Your Ref: OWPC26216
Our Ref: A/30/20/PL 27-02-2020
Please ask for:
David Spring

Demolition of existing building & construction of 2-bedroom bungalow with associated parking & landscaping (resubmission following A/146/19/PL). This application affects a Public Right of Way.

Land to the Rear of 1 The Heathers Arundel Road Angmering

Proposed Bungalow Plans and Elevations

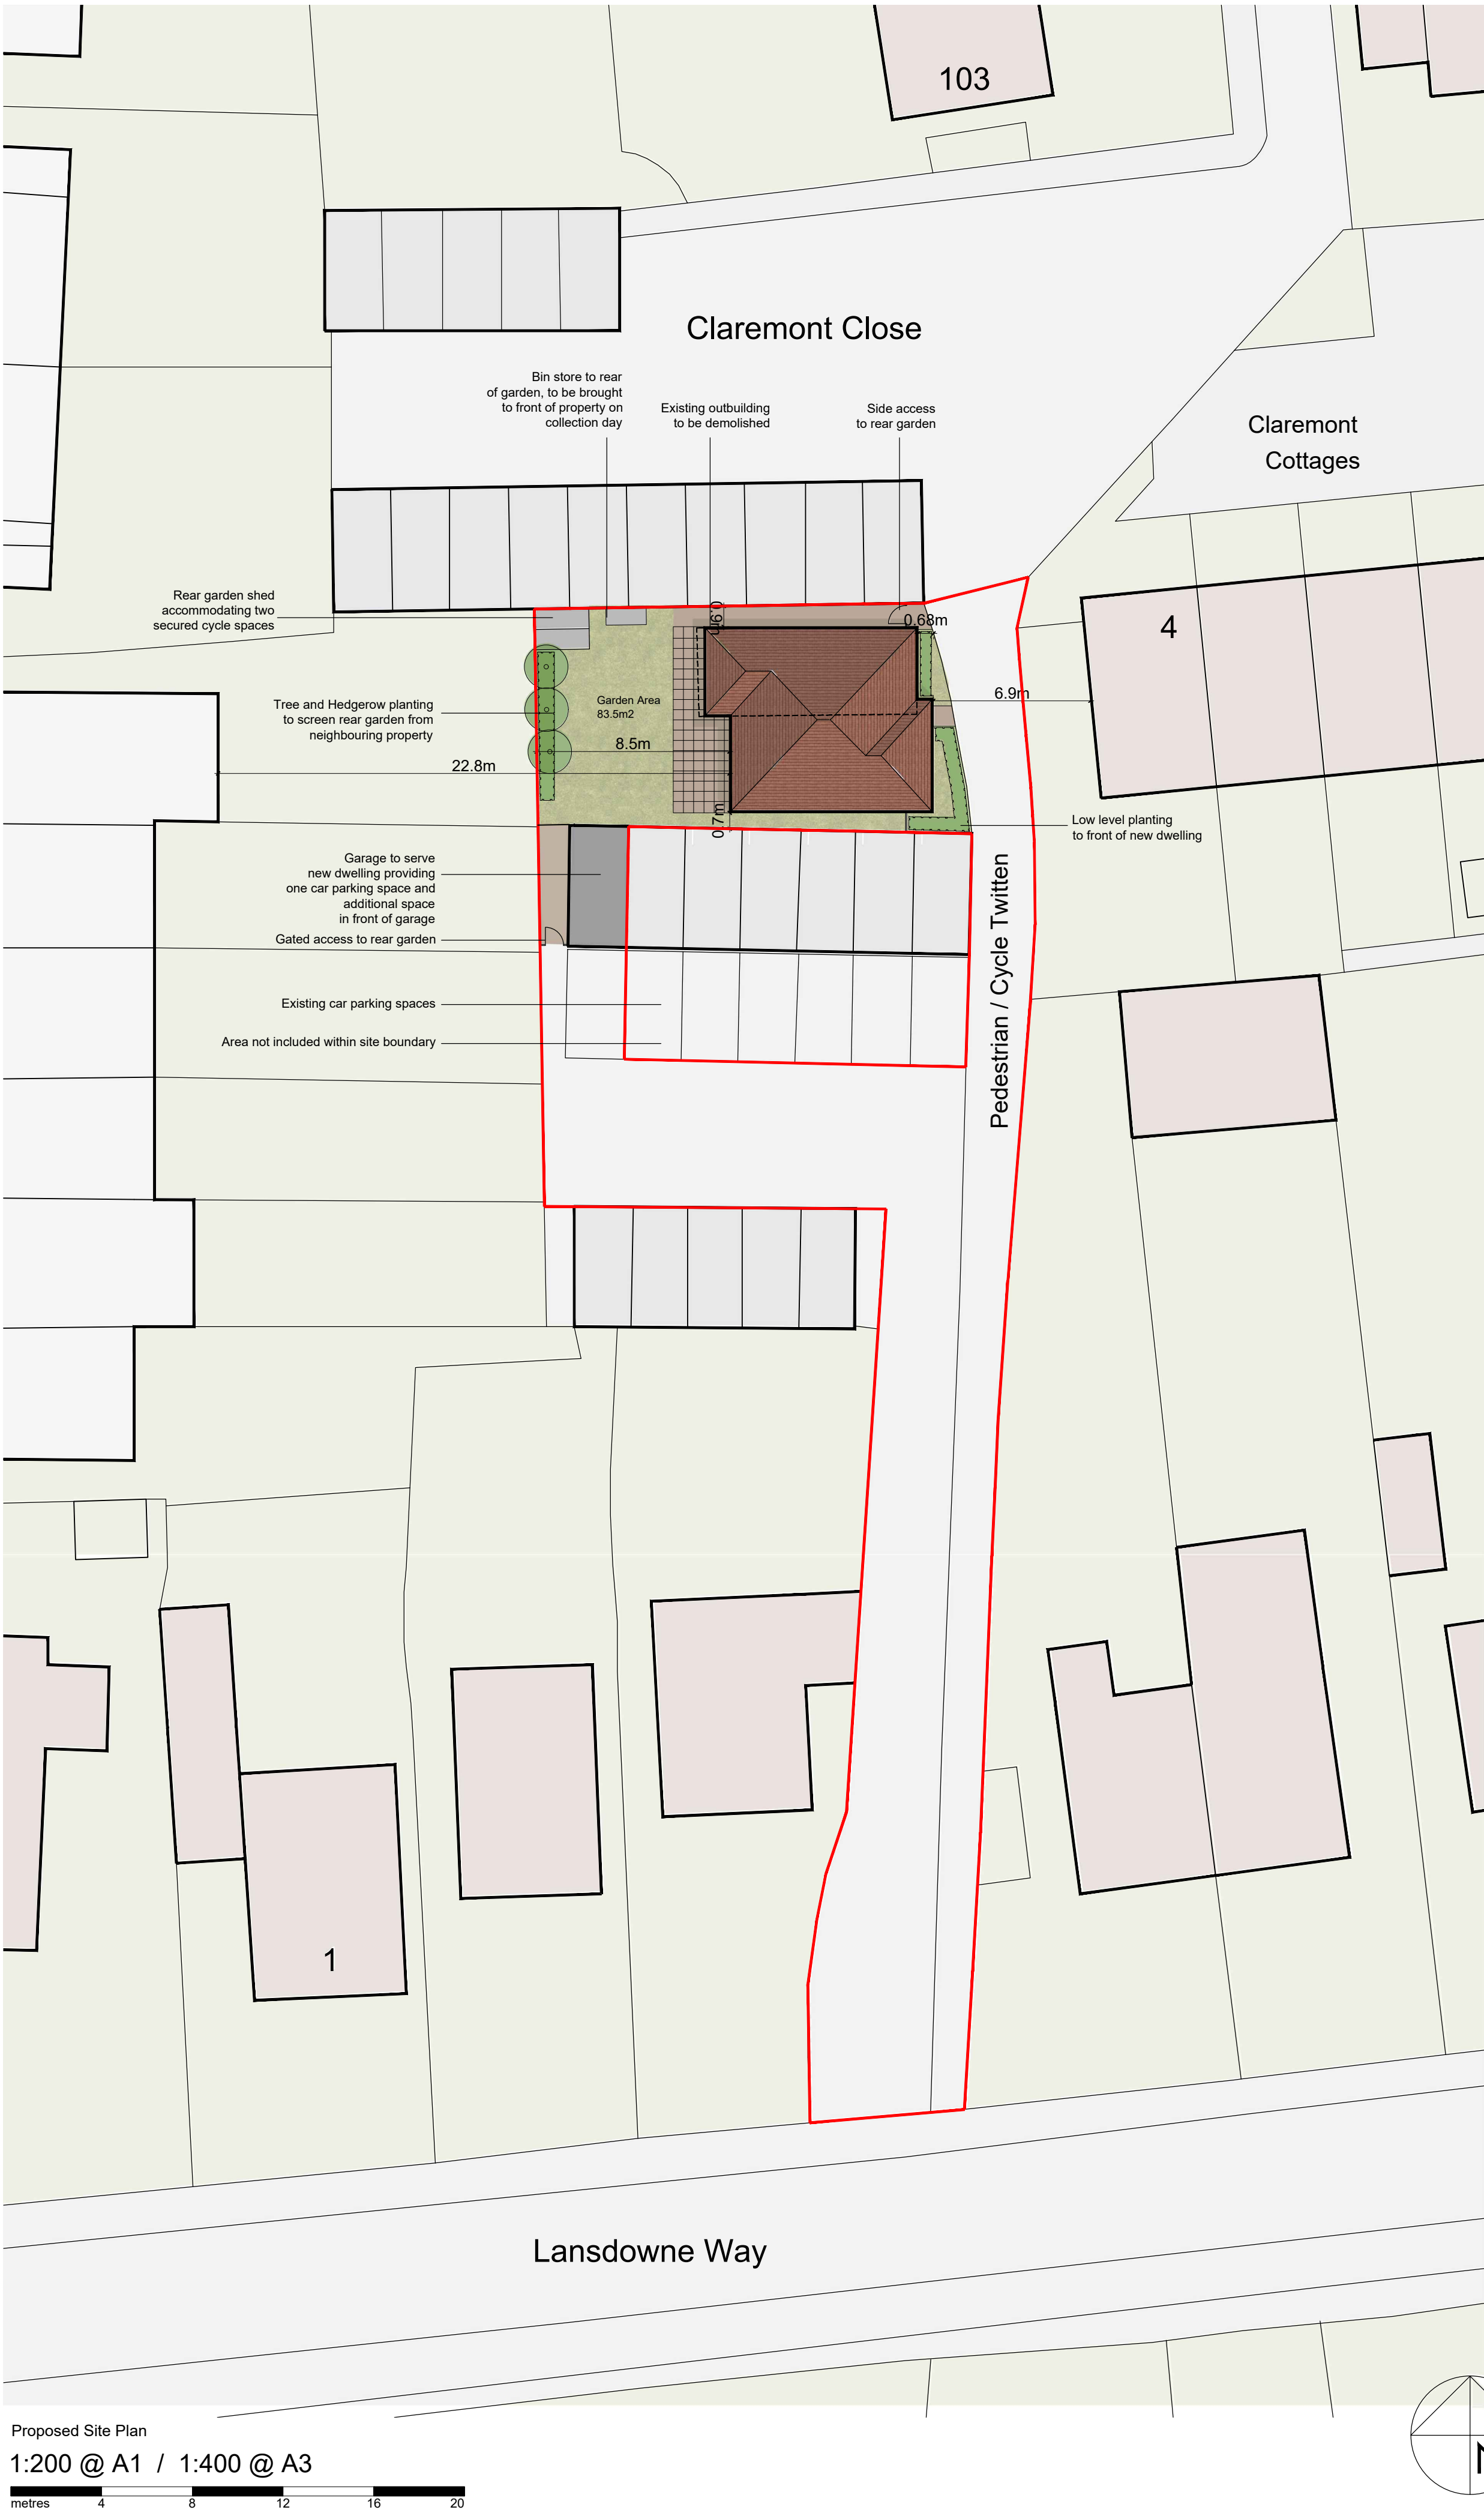
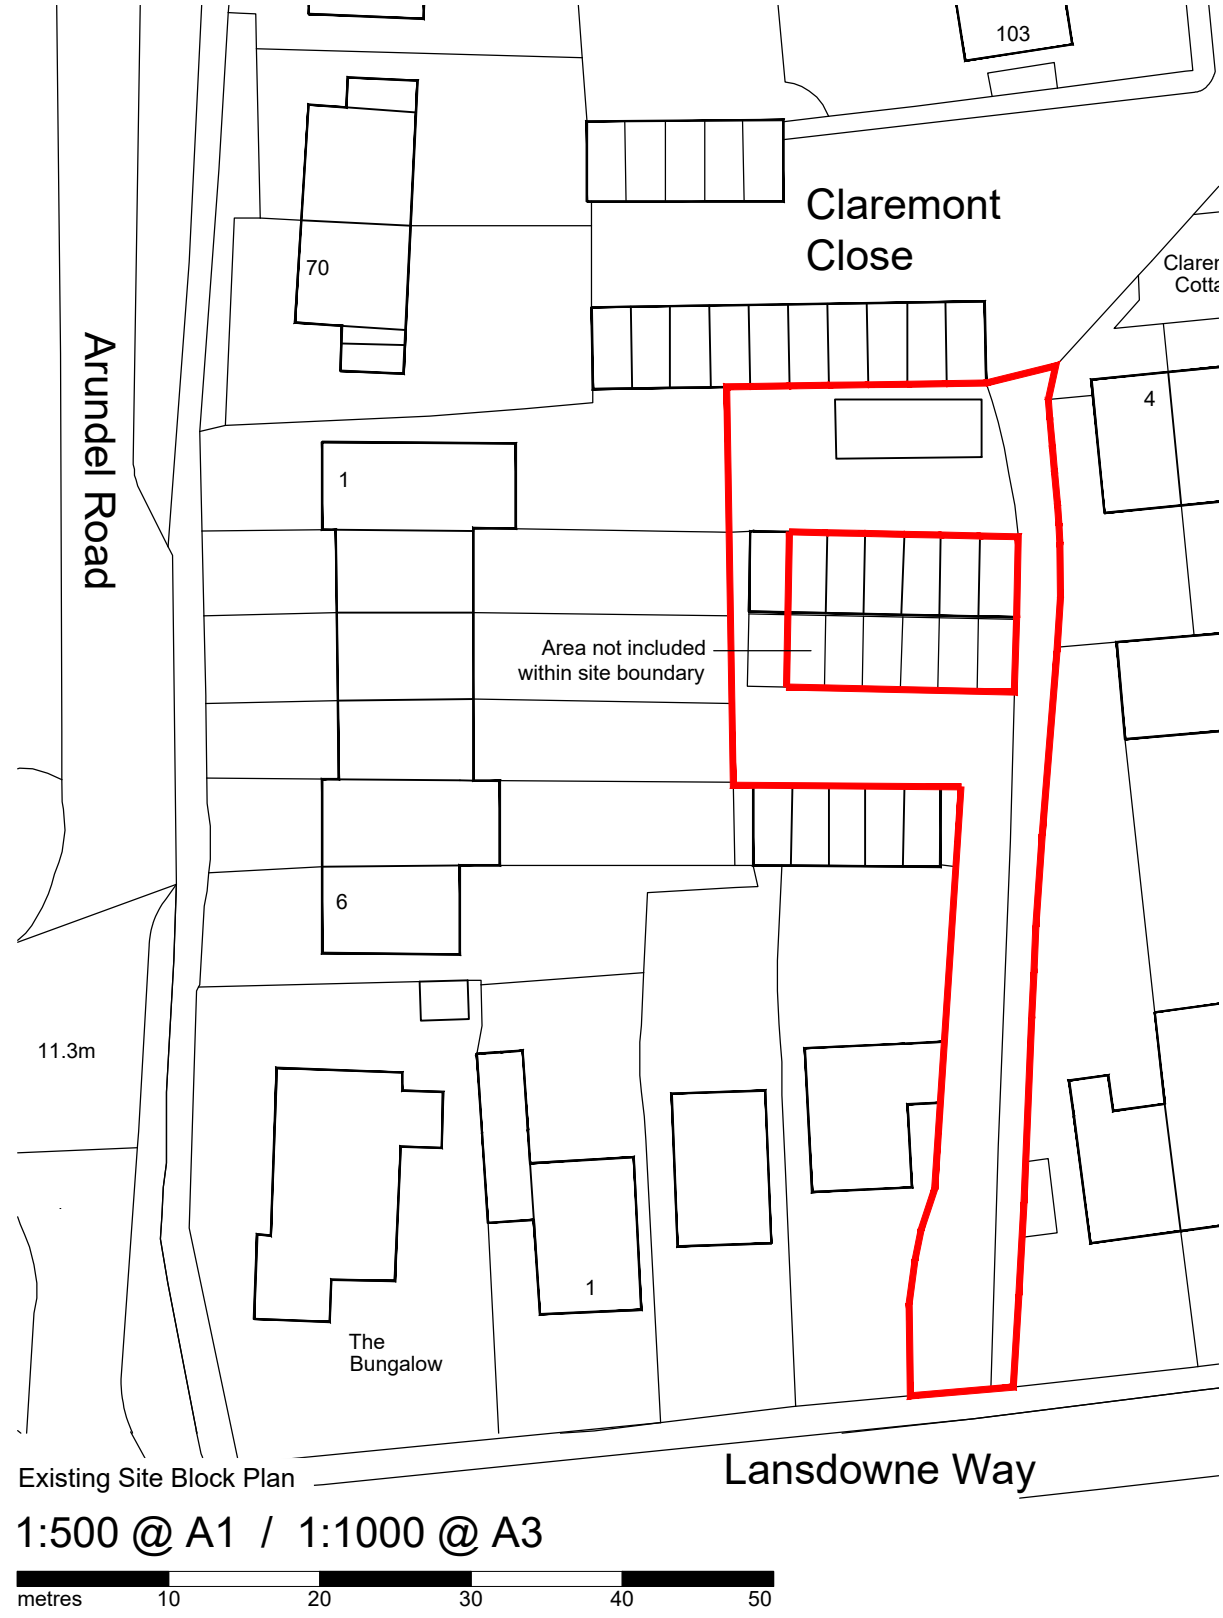
*Foot print of house seems to be even larger than rejected application.
There is not space for two cars to be parked as indicated. This would limit access to other
garages and properties.*
